**SSD 6626 - SICEEP Darling Square - Mixed Use
Residential Building within North-East Plot**

**Submission
OBJECTION**

21 November 2014

SICEEP - SSDA7 Shadow Study

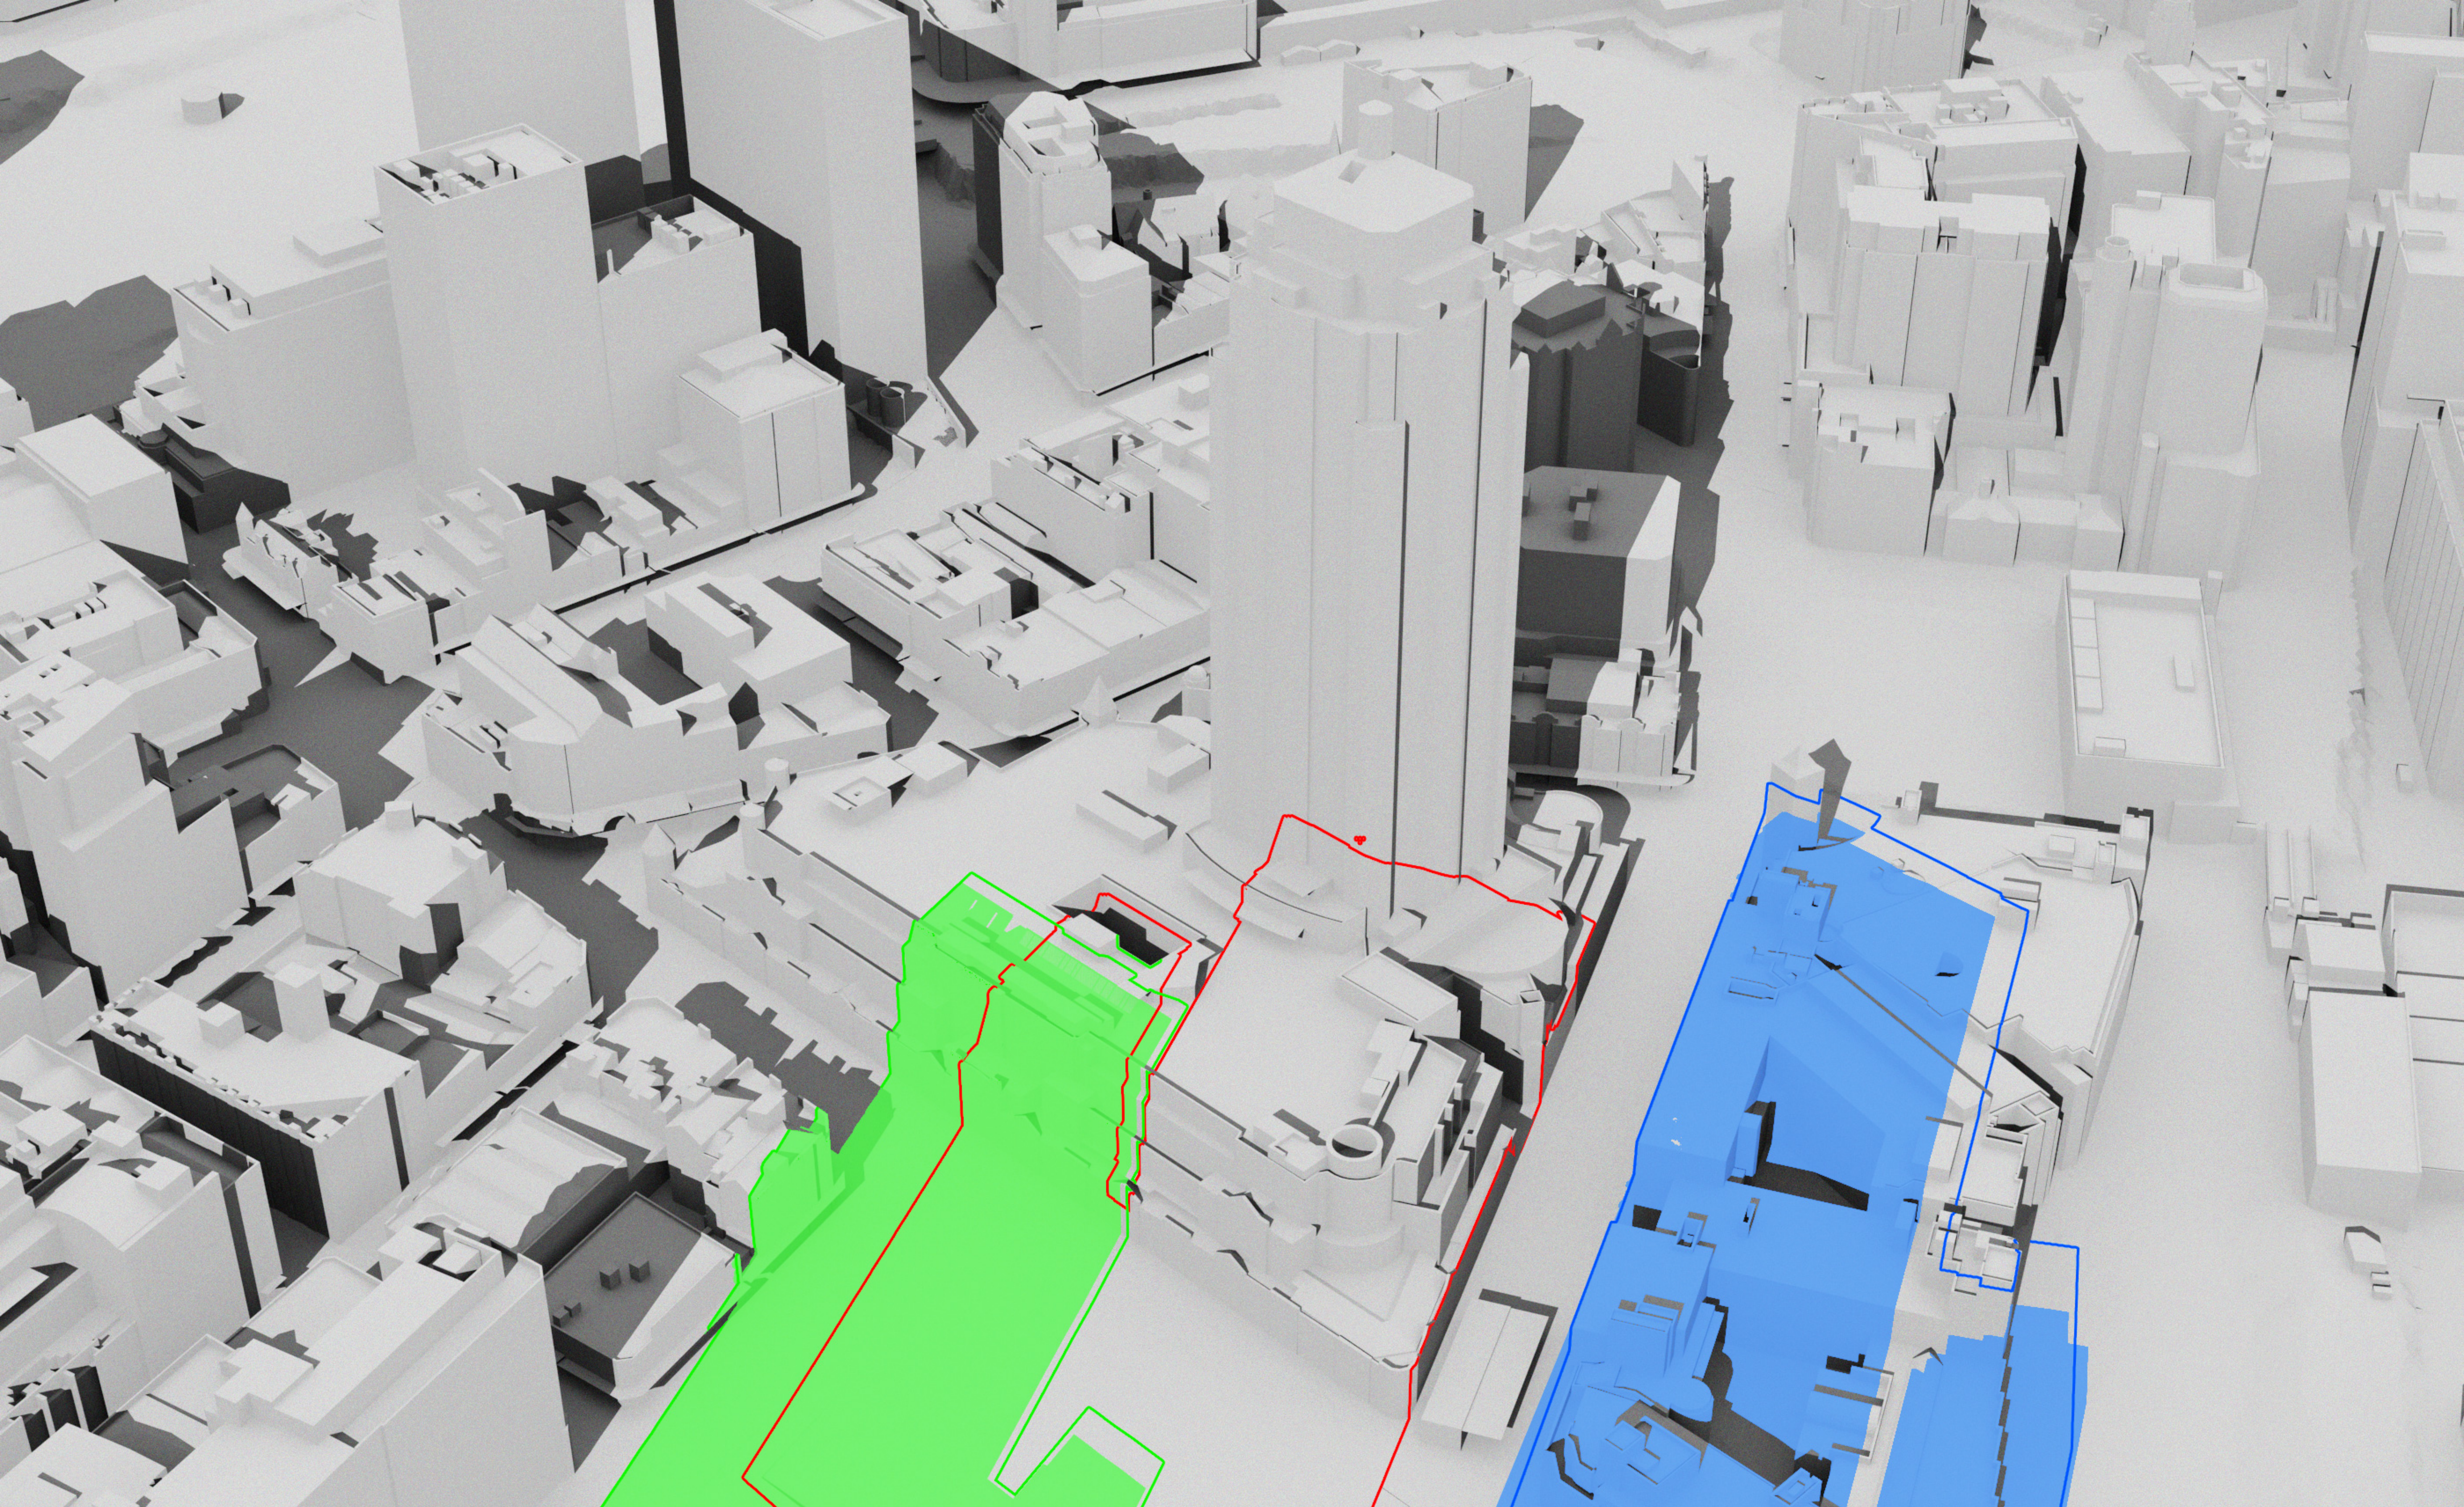
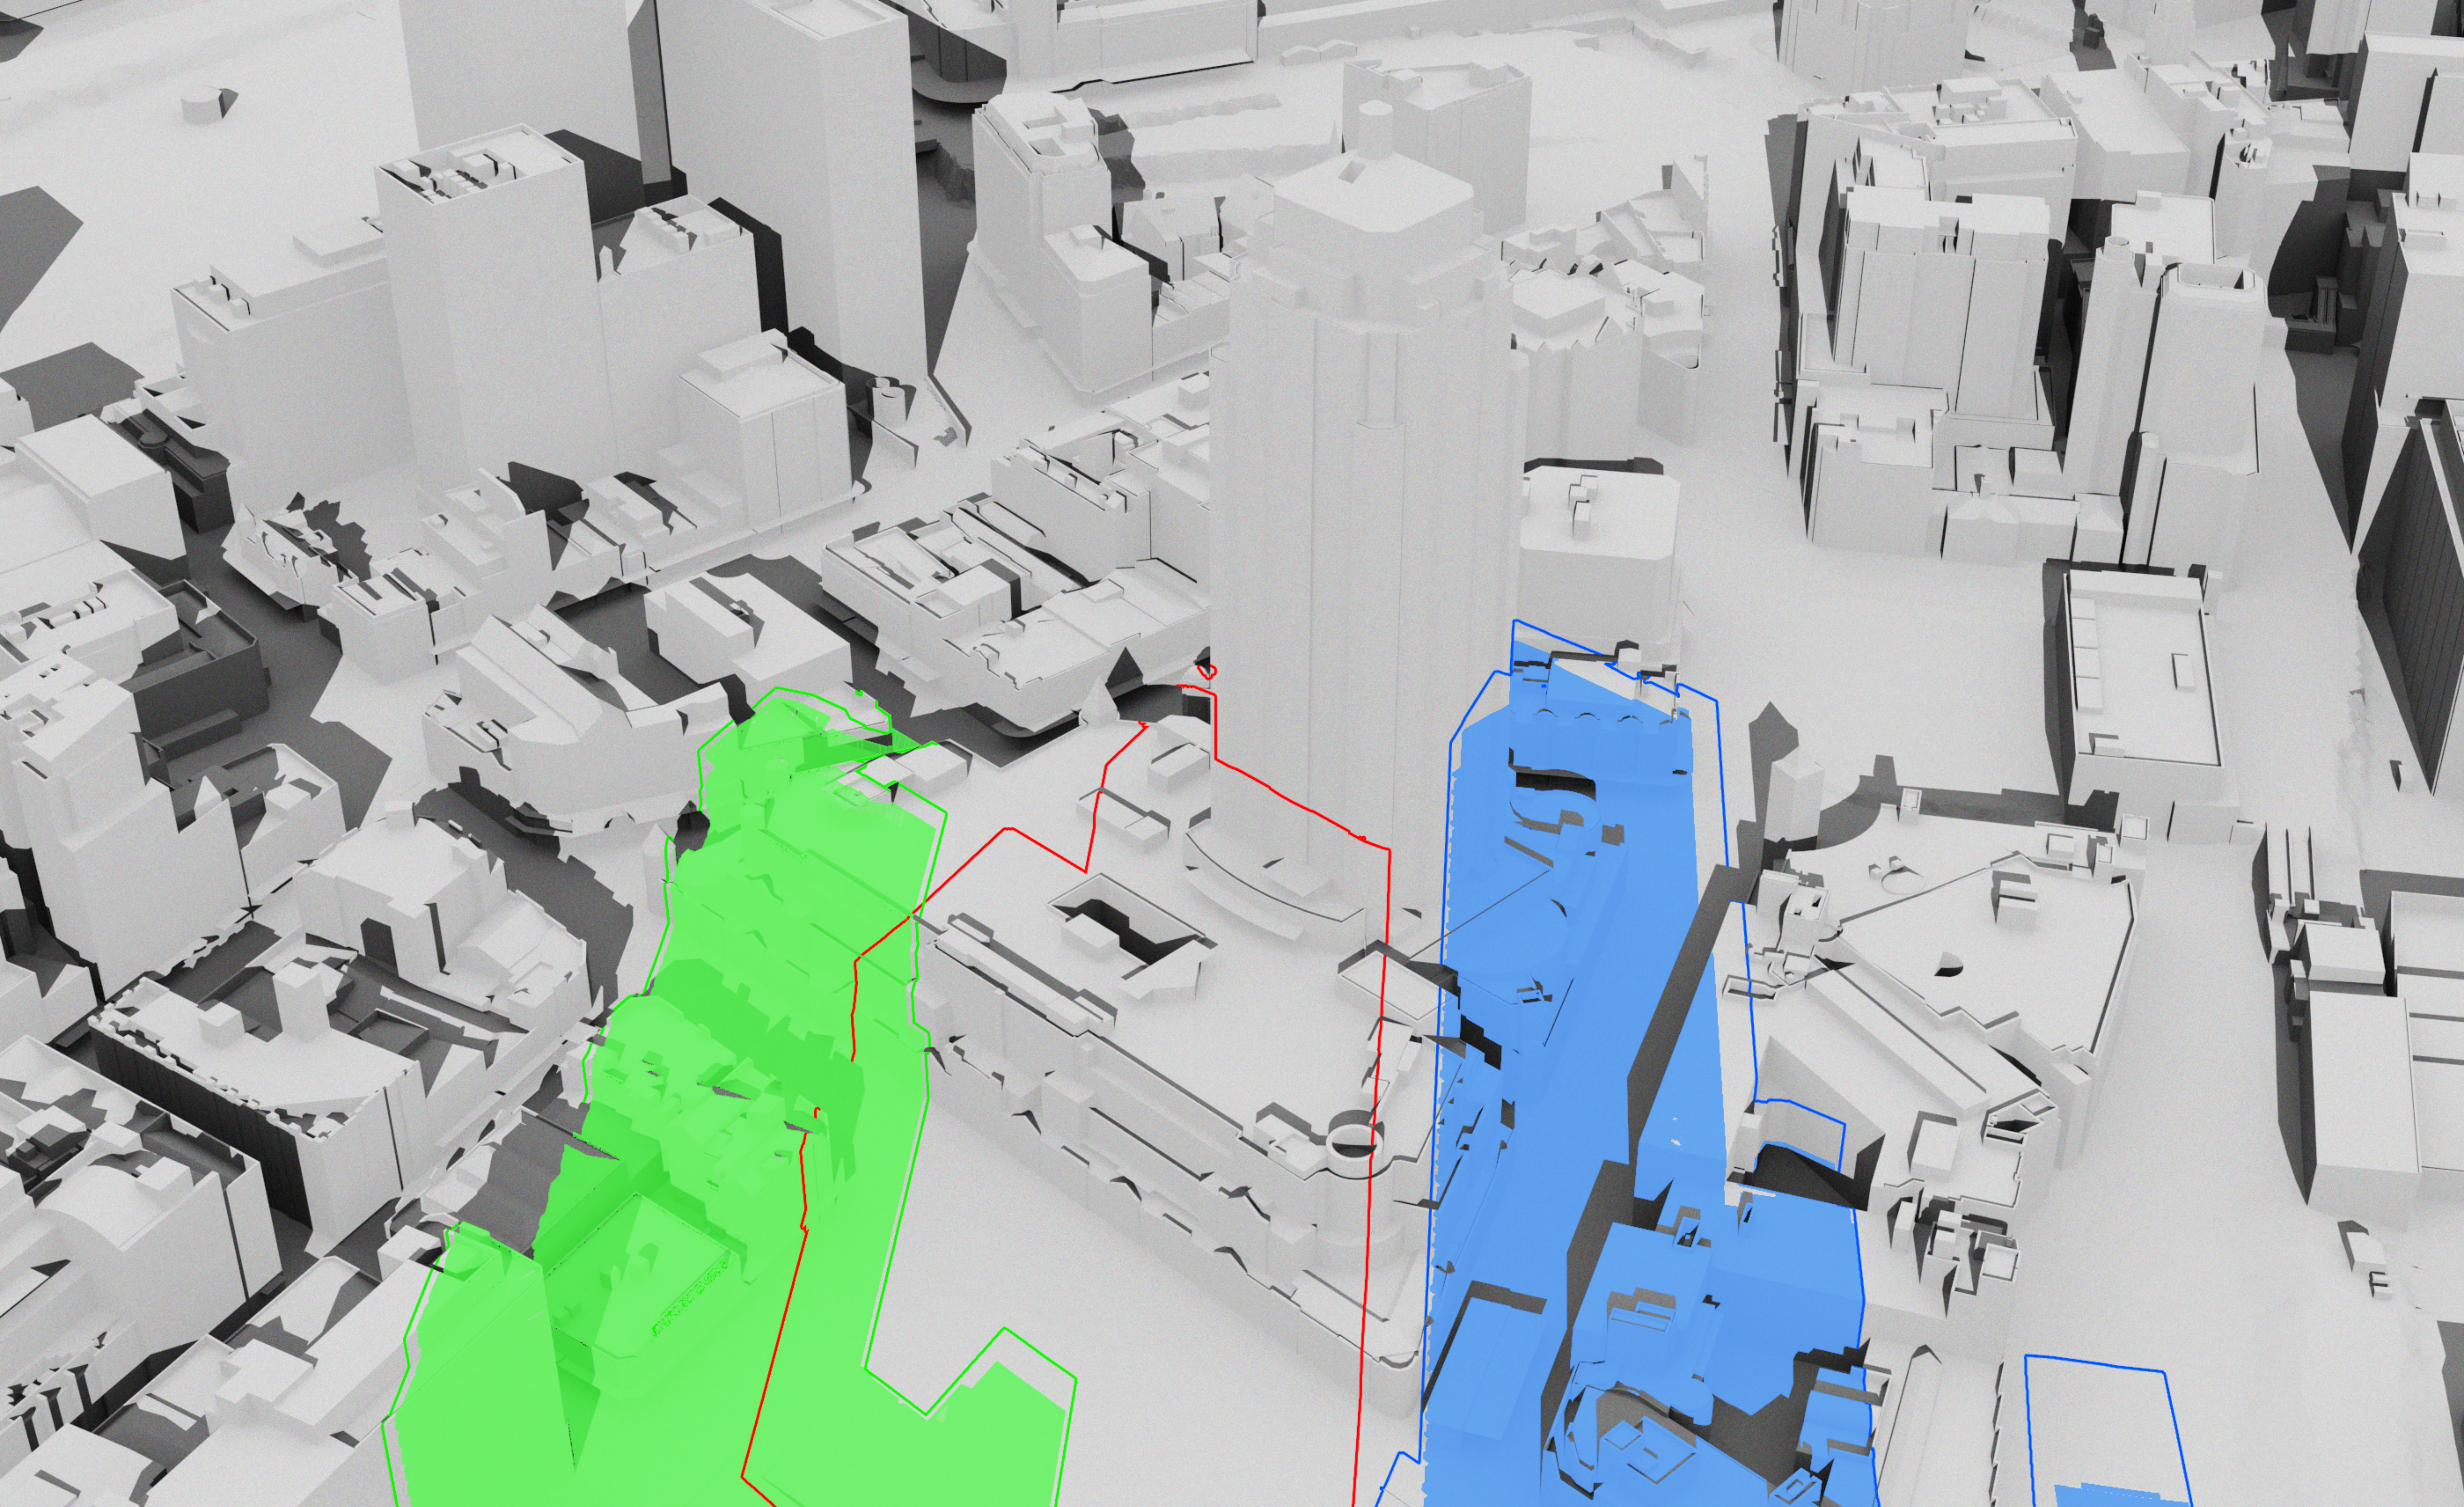
Excessive overshadowing of The Peak podium

With respect to the podium of The Peak Apartments, the EIS states that "The landscaped podium associated with The Peak Apartments will continue to receive at least two hours of solar access, ensuring compliance with the intent of the Sydney DCP 2012.". Although this statement is true, two hours is a major reduction from the existing 21 June daylight access of about six hours.

Excessive overshadowing of public open space - the new square - "Haymarket Square"

I agree with the City of Sydney's view that "excessive morning shadows are cast into the outdoor and café areas in the new square by new surrounding building edges. In order to improve morning sun access to the square in winter, it is recommended that the building heights lining the new square be reduced and the floor area relocated to the surrounding streets podium edges..." Source: City of Sydney, SSD 5878 (SICEEP) The Haymarket submission, page 34.
